Third Submission of objections SSD15_7056

Objection on the Grounds of Overdevelopment of the Site

Submission for Job: #7056 Remediation, Restoration and Adaptive Re-Use of Campbell's Stores

Drawing Title
LANDSCAPE PLAN

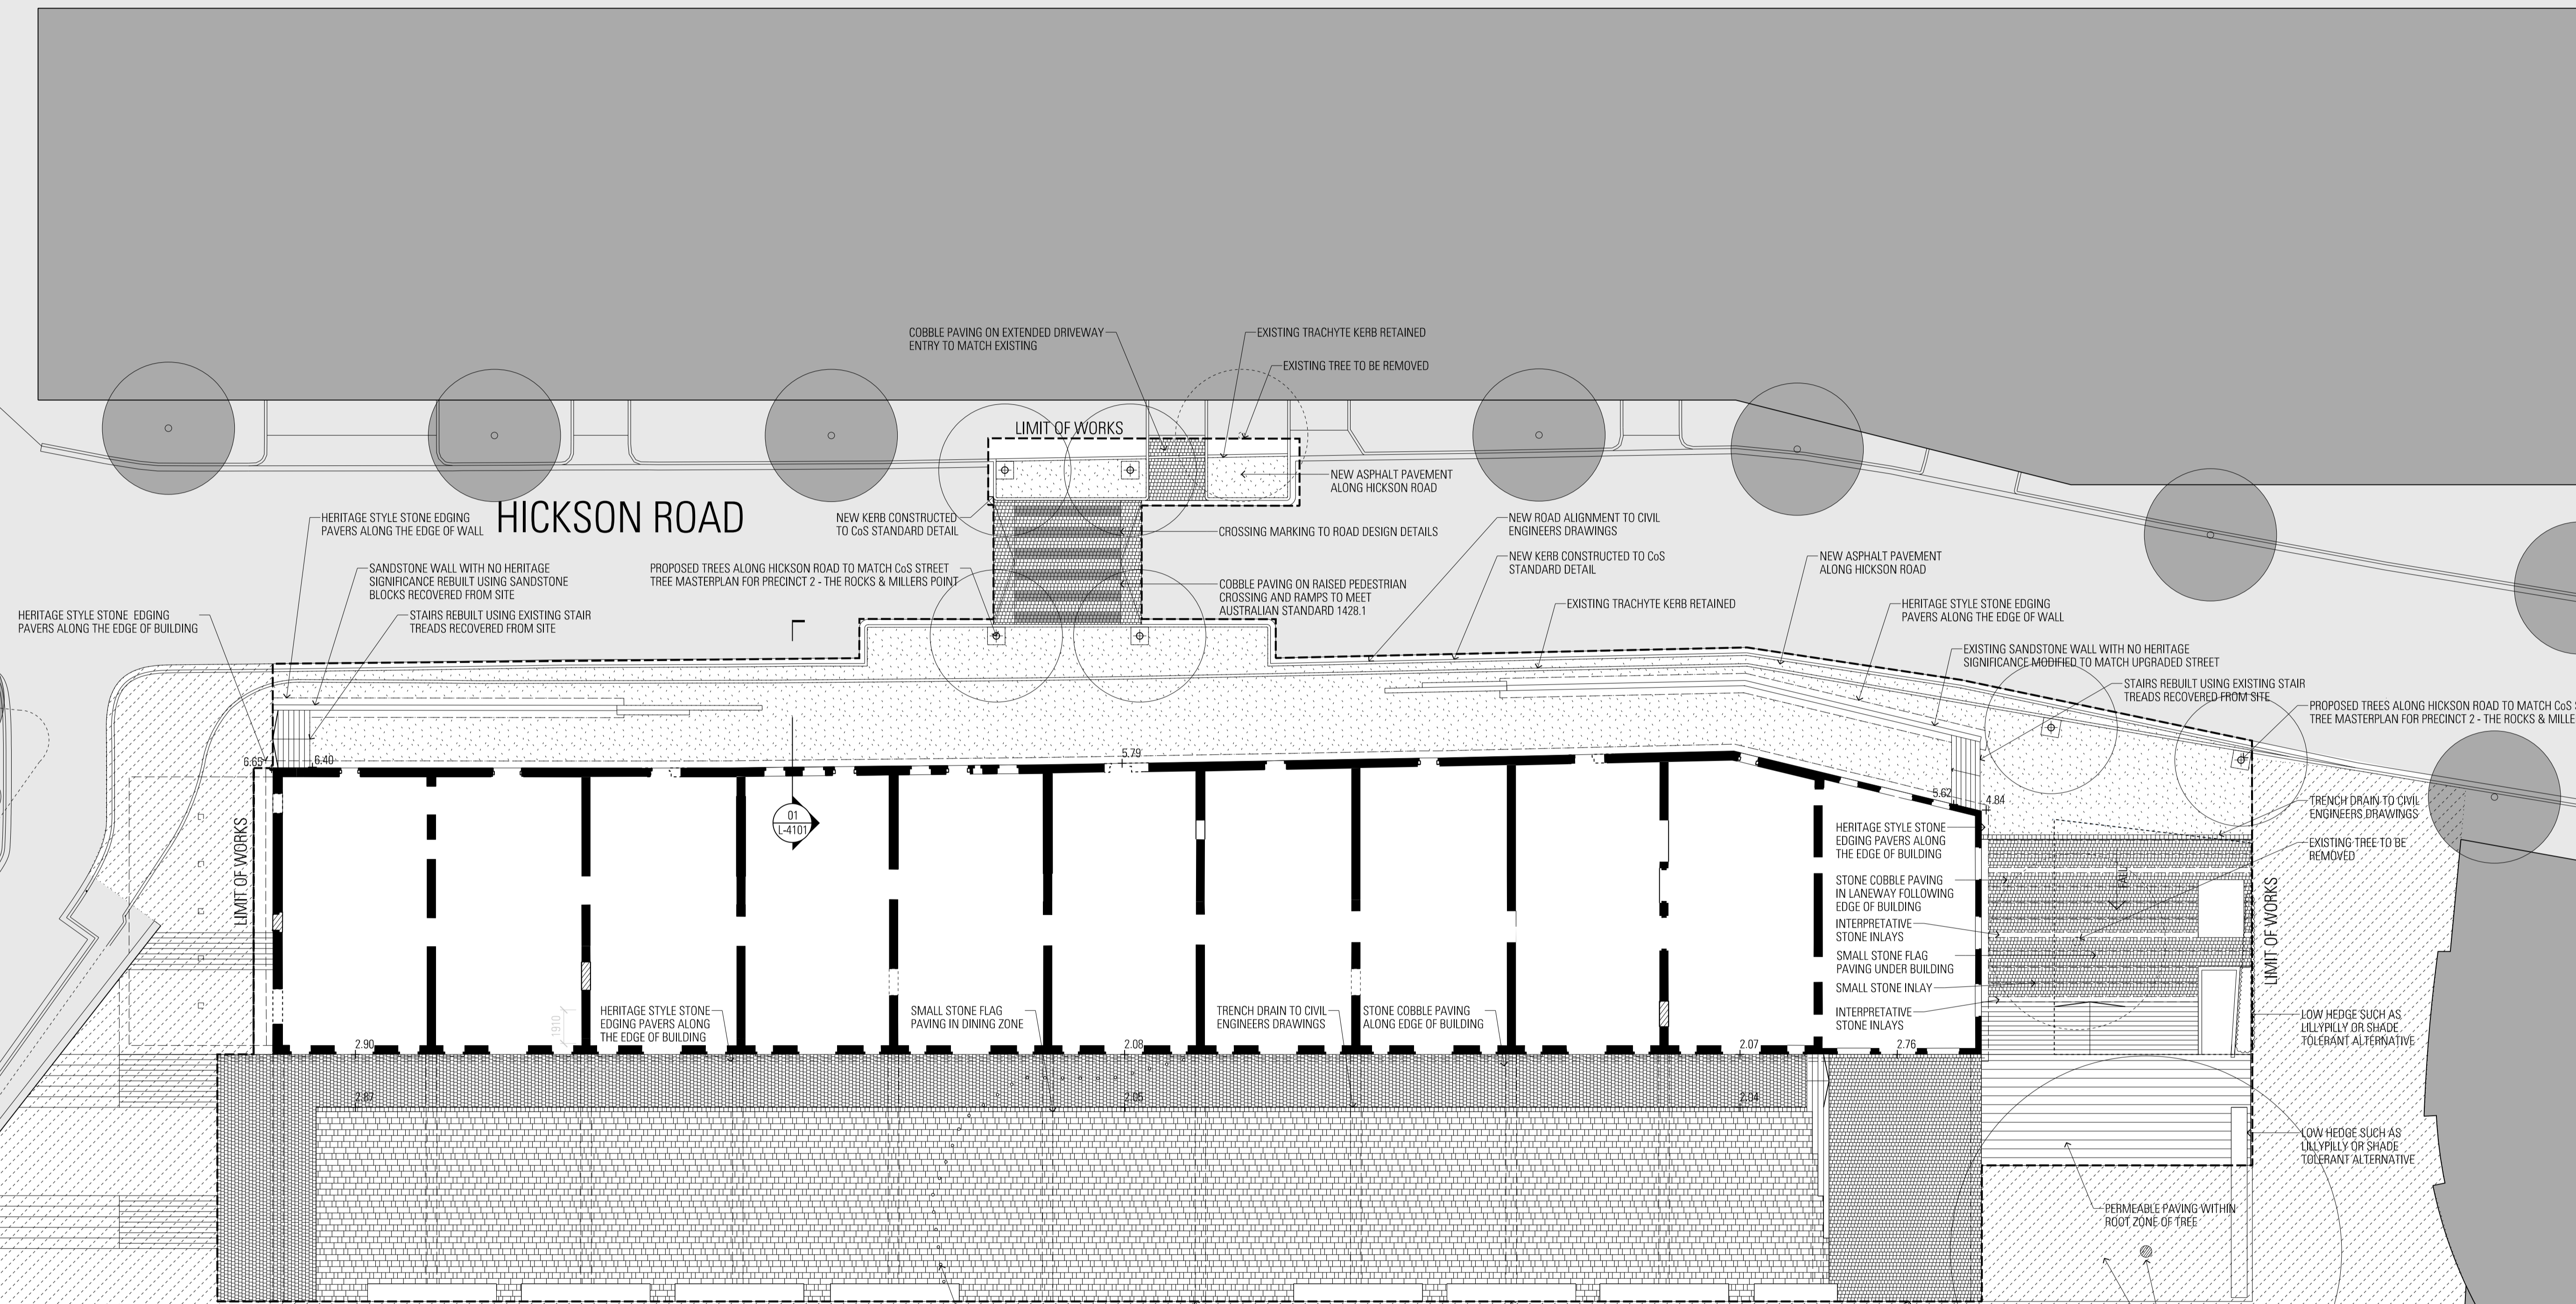
Substantial fig trees, such as this significant tree, are planted with plenty of space around them in areas such as the Botanic Gardens, Observatory Hill, Hyde Park and Bennelong Park. The proposed building will be located to the immediate west and slightly within its existing canopy. This will compromise the space needed to create an appropriate landscape setting for the tree.

01 WEST ELEVATION  
SCALE 1:200

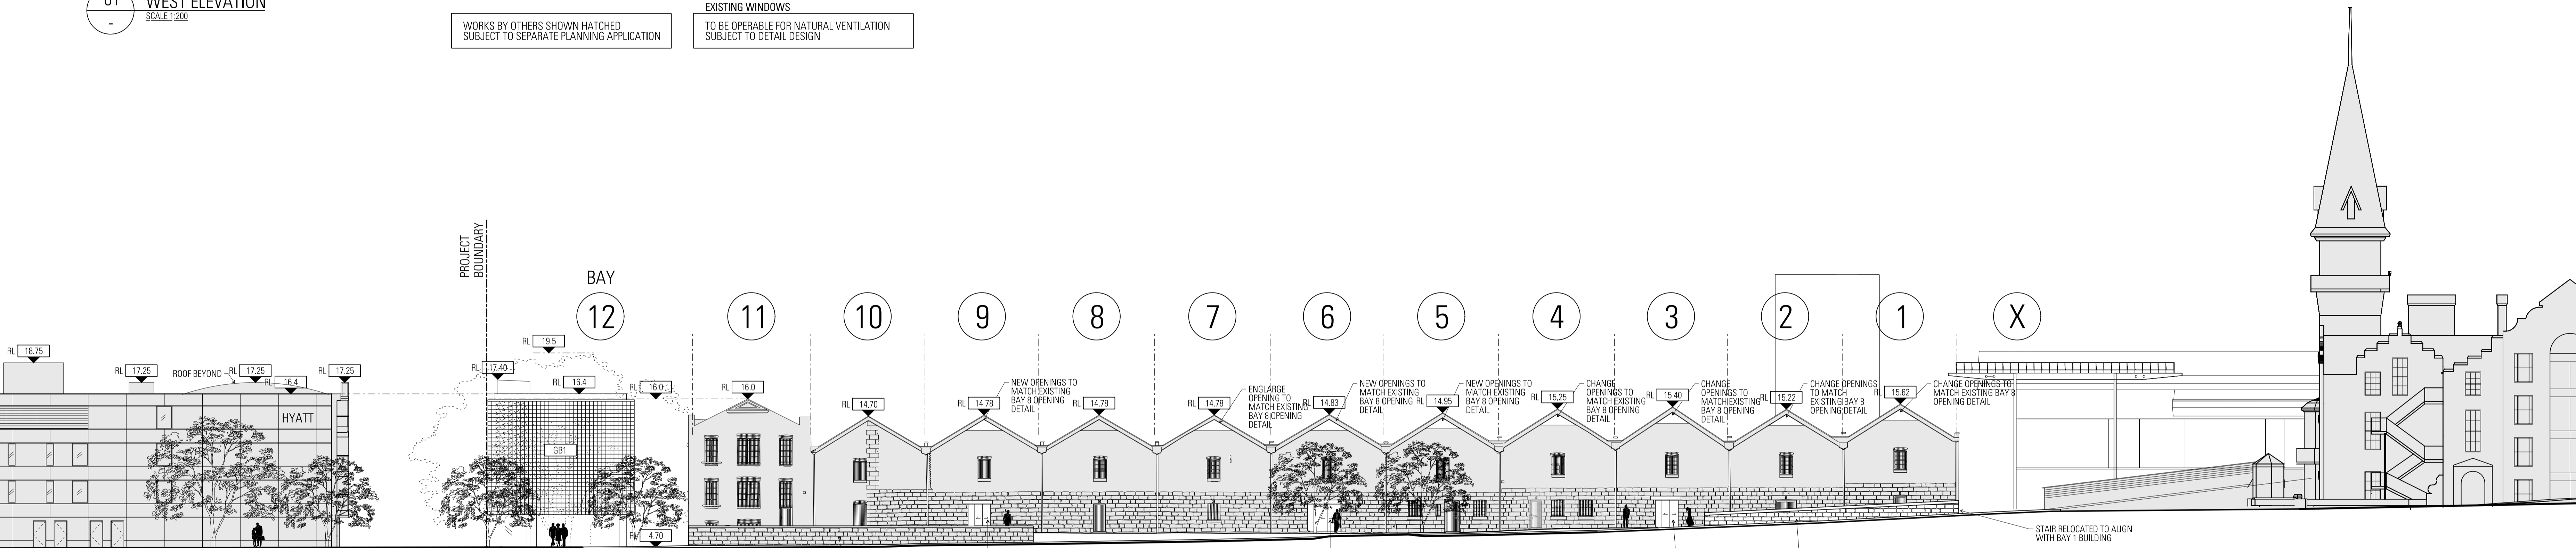
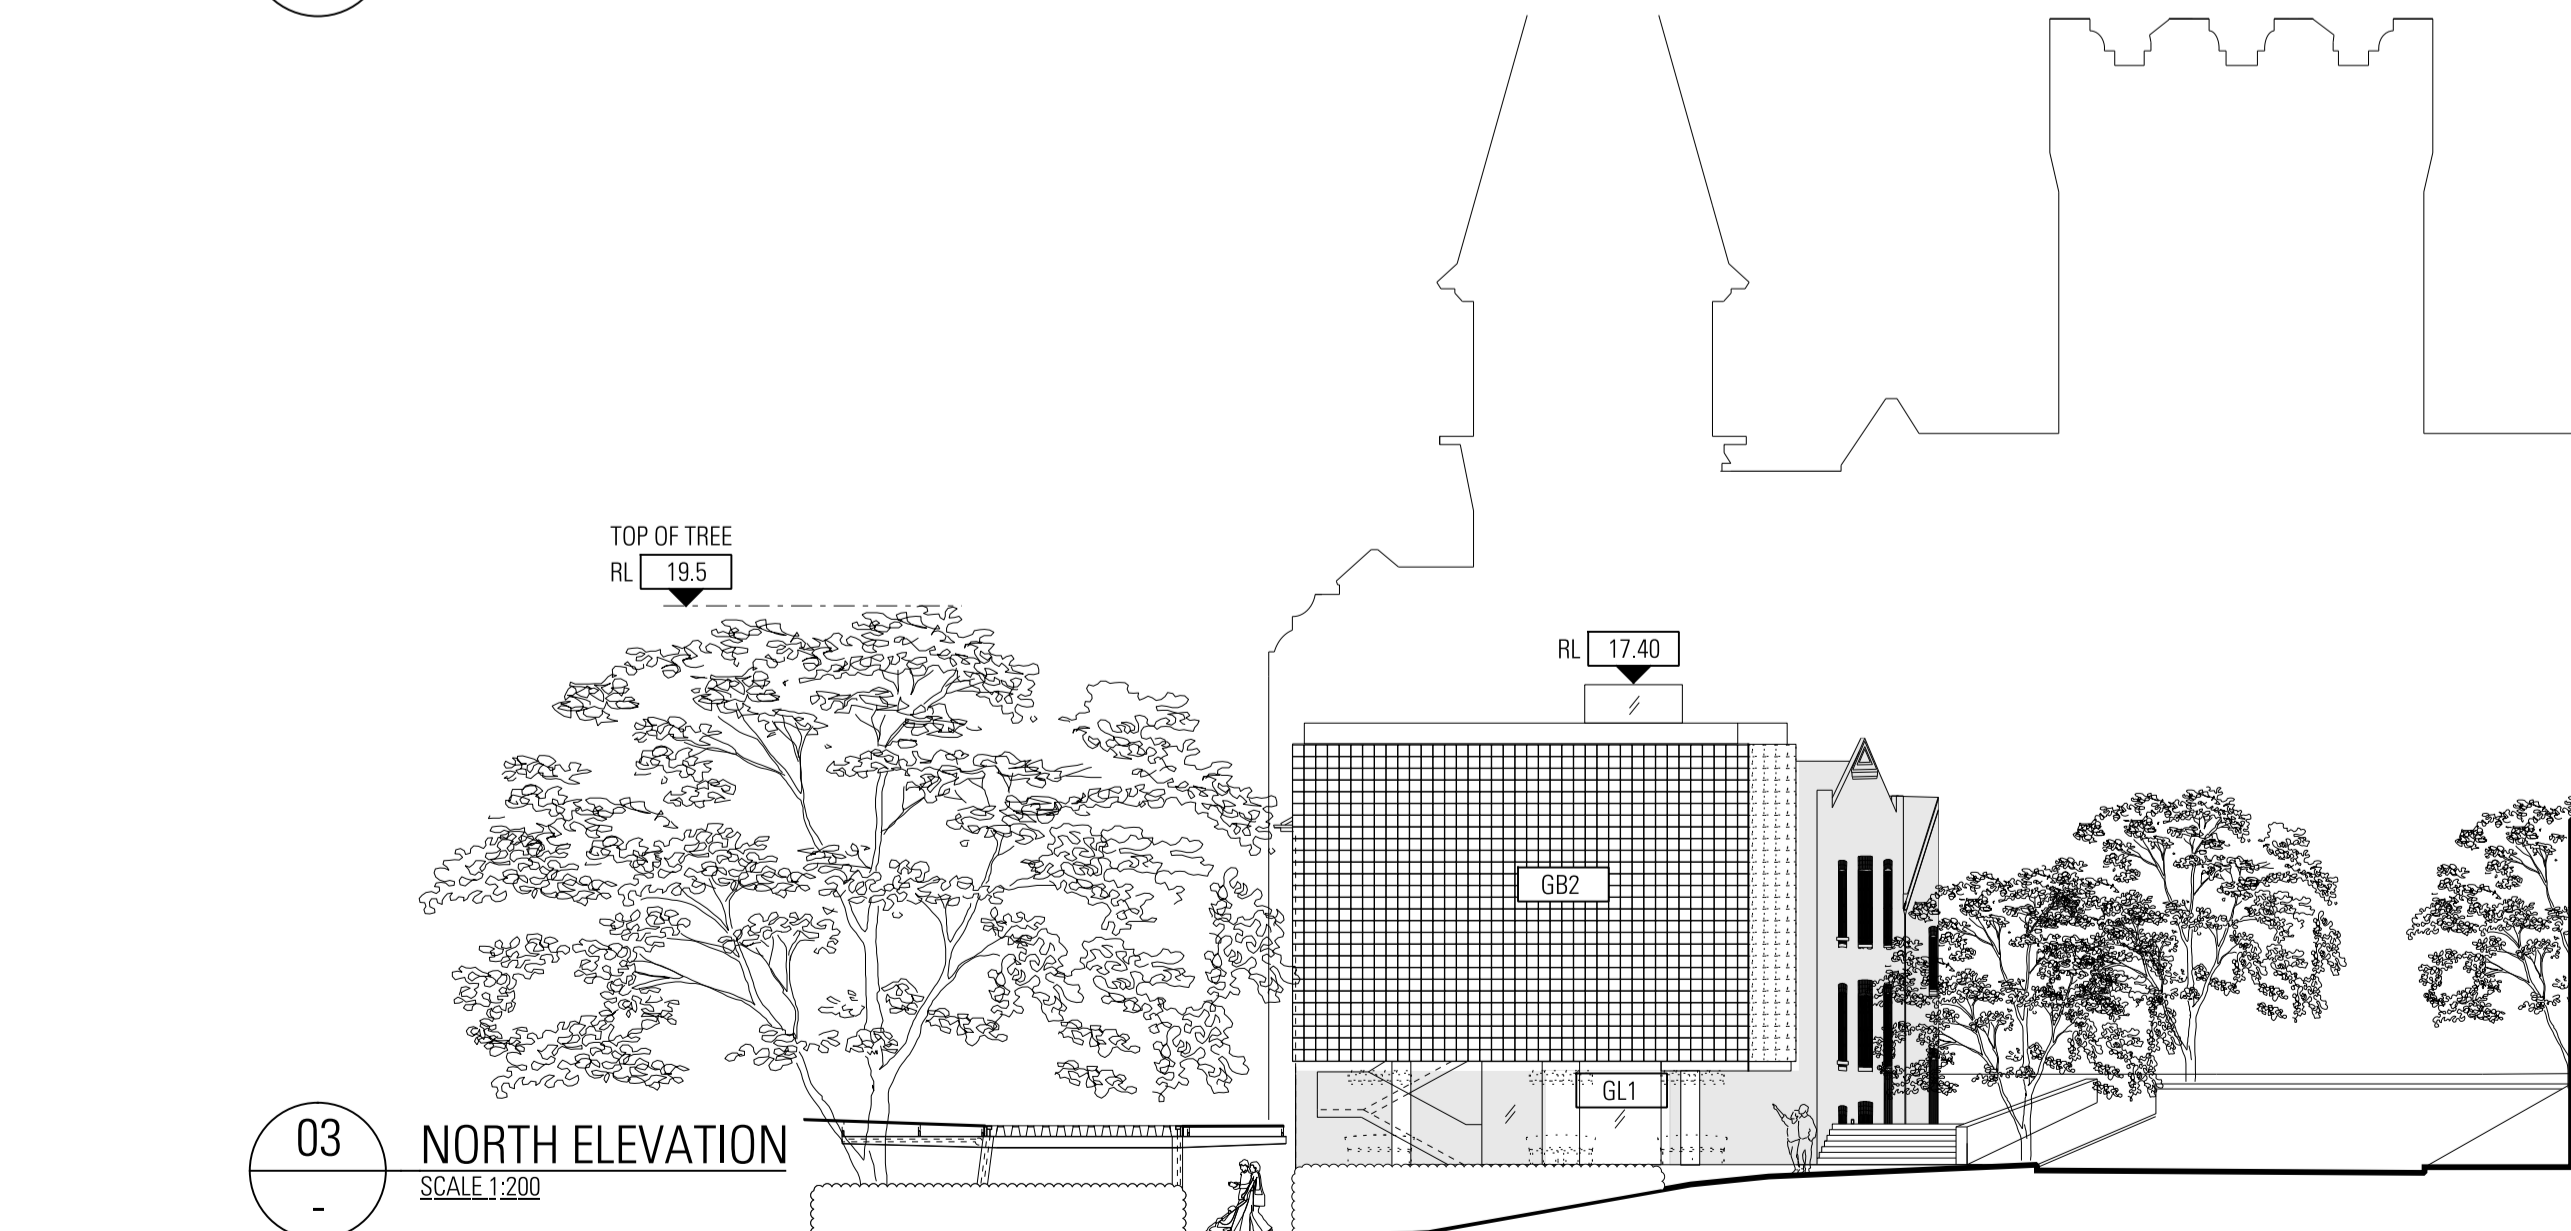
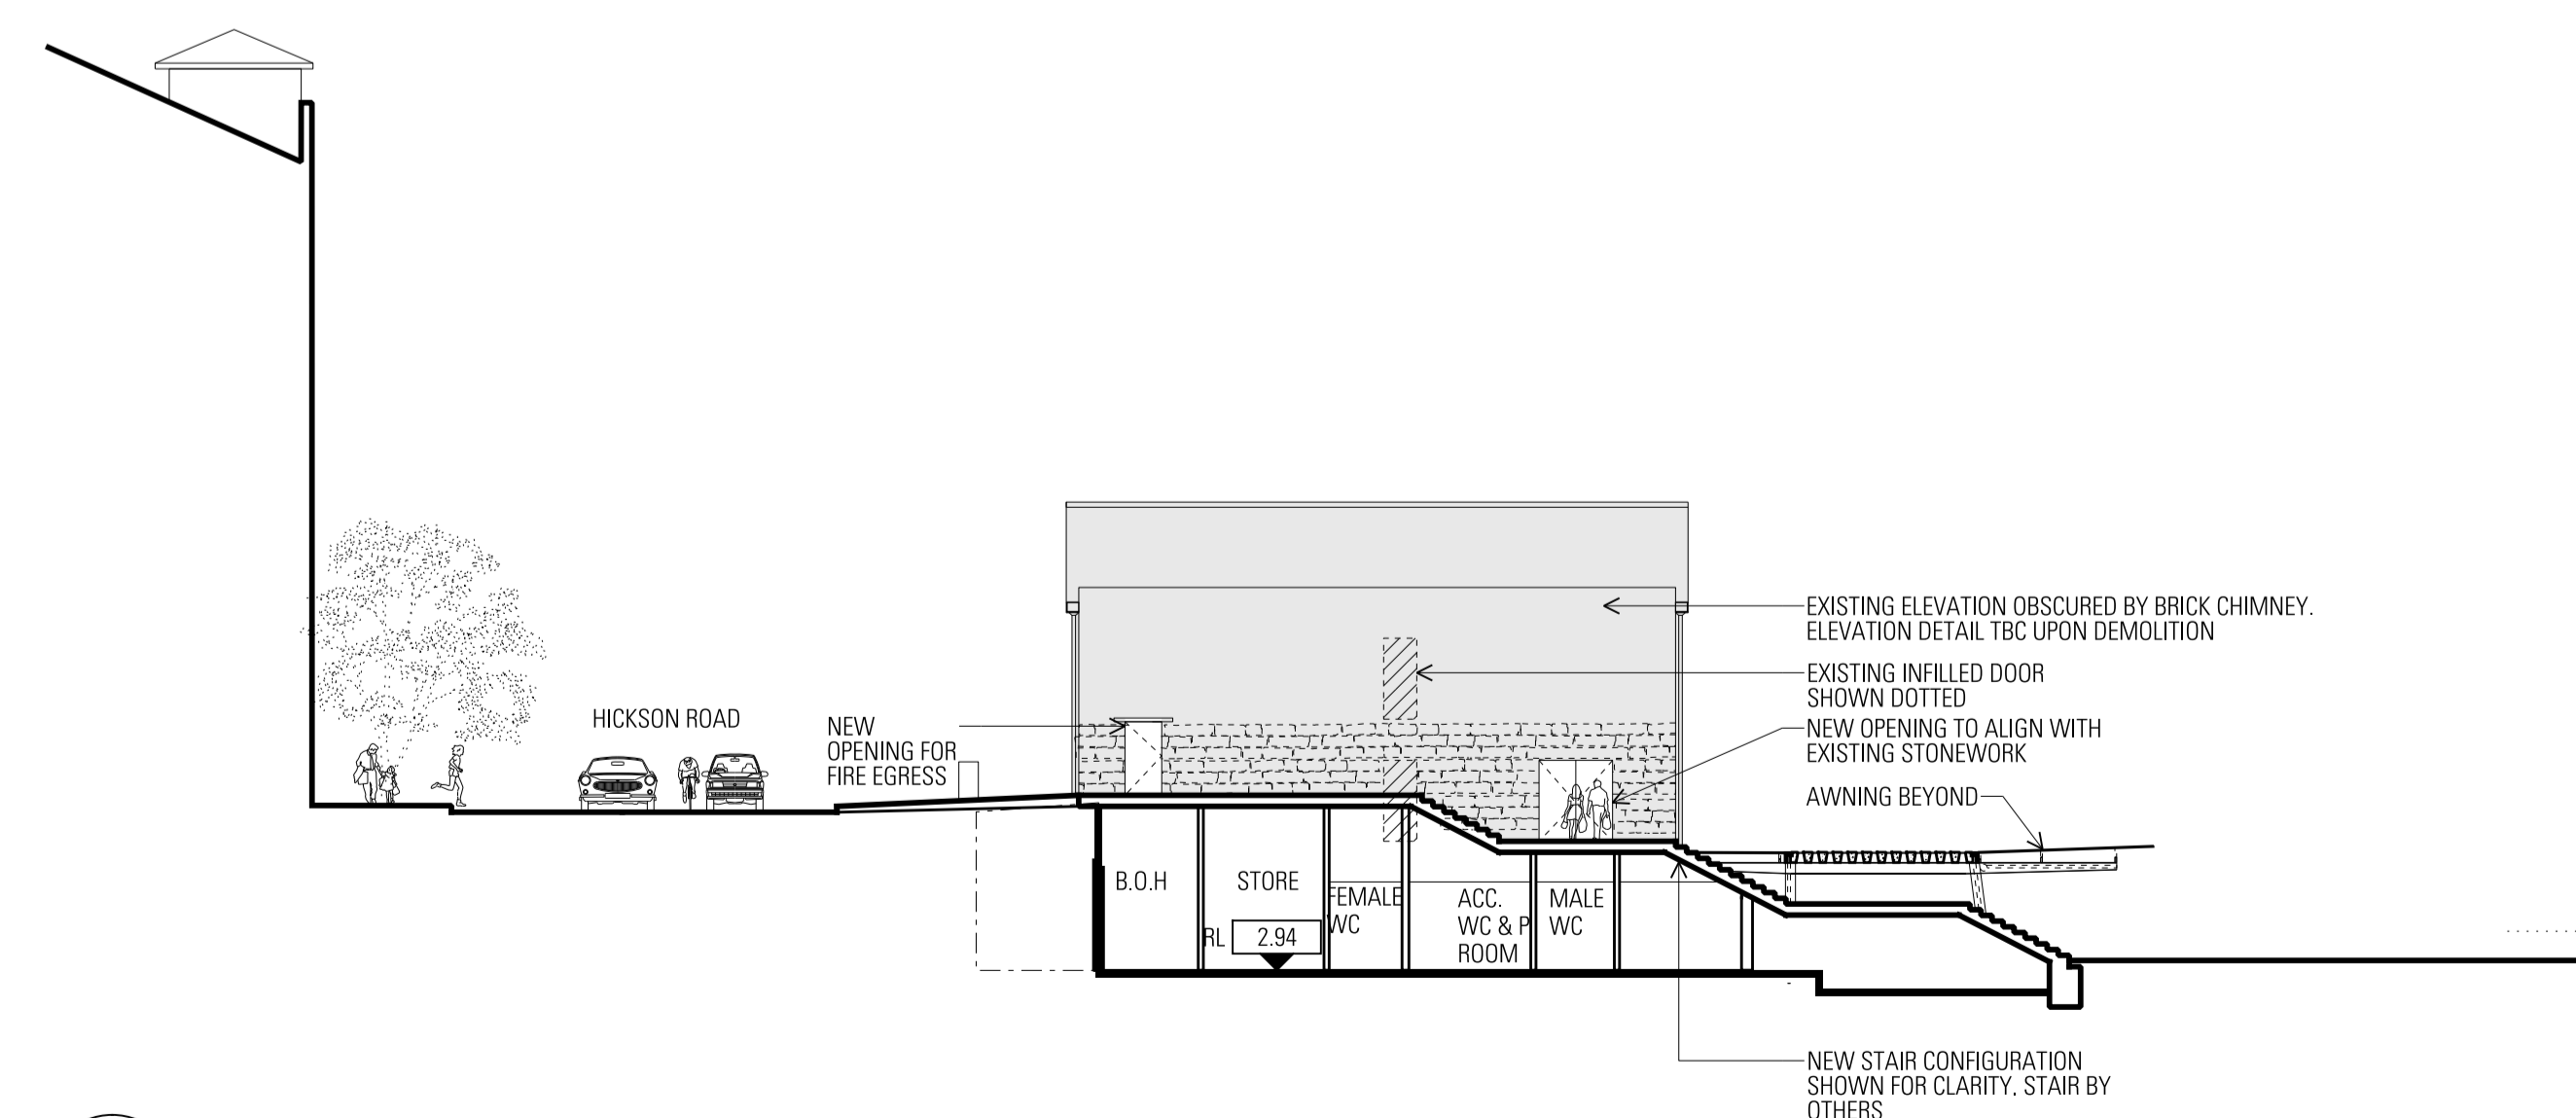
The height and bulk of the building will dominate the Stores building and dramatically change its setting. The basement for the building effectively 'buries' the ground floor of the Stores to a height of approximately 2m and visually screens the entire northern elevation of the Stores. The negative impacts on the heritage significance of the Stores has been raised in my previous submission.

The basement for the proposed glass building requires raising the ground level by almost 2m. This will make it impossible to provide a non-stair access at this location. The proposed stair access is an unacceptable compromise that will not meet the significant access needs of the large numbers of people who have to use a stroller or wheelchair. The development will result in the permanent loss of the opportunity to provide this much needed access to all who might need it.

The visual connection to the harbour is reduced not enhanced as a consequence of the low height (2.5m) of the open undercroft to

In an attempt to meet the specific site priorities, of enhanced pedestrian access and visual connectivity to the foreshore, the architects had to elevate (if not levitate) the building above ground level by 2.5m.

The elevated, floating, building form is totally unsuitable to this location and results in a design that is dramatically out of character with the area. The building lacks any element of 'local' character that integrates it into the urban fabric of The Rocks. While there is a very valid place for international style architecture within the busy urban centre of a city's CBD, and elsewhere, new buildings within conservation areas need to maintain a local character even within a modern architectural form.
